Application Ref:	3/2021/0314	 <div>Ribble Valley Borough Council</div> <div>www.ribblevalley.gov.uk</div>	
Date Inspected:	25/1/2021		
Officer:	BT		
DELEGATED ITEM FILE REPORT:		Decision	Approval

Development Description:	Replacement of existing hipped roof with a hipped roof with an increased ridge height to form additional bedroom in the roof space. Resubmission of 3/2020/1023.
Site Address/Location:	57 Ribchester Road, Wilpshire. BB1 9HT

5 Proposed Front (north) Elevation
1 : 100

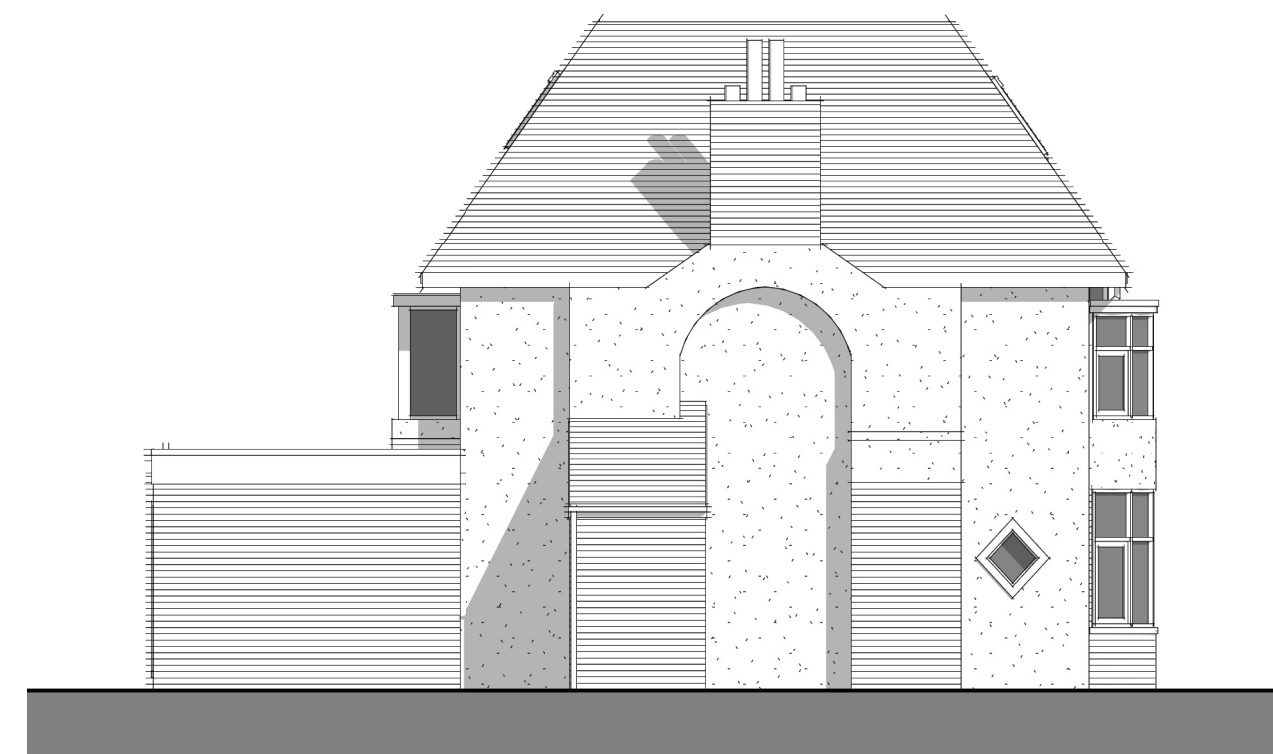
The proposed second floor level will incorporate a set of French doors and a small balcony on its Northern front elevation. The French doors and balcony will allow some overlooking into the front garden of No. 57a Ribchester Road however this area is already viewable from the property's existing first floor windows. Moreover, the proposed balcony will be situated within the roof plane of the main dwelling with no outwards projection therefore it is not considered that the proposed works would allow any new opportunities for overlooking into private areas.

The proposal will incorporate a modified hipped roof design which includes an increase of 0.7 metres to the property's existing roof ridge height and the addition of several roof lights. These alterations will be viewable from within the public realm therefore the proposed works will have some visual impact however given the relatively small increase in roof ridge height and the partial retention of the property's hipped roof design it is not considered that the proposed works would lead to any adverse impact upon visual amenity.
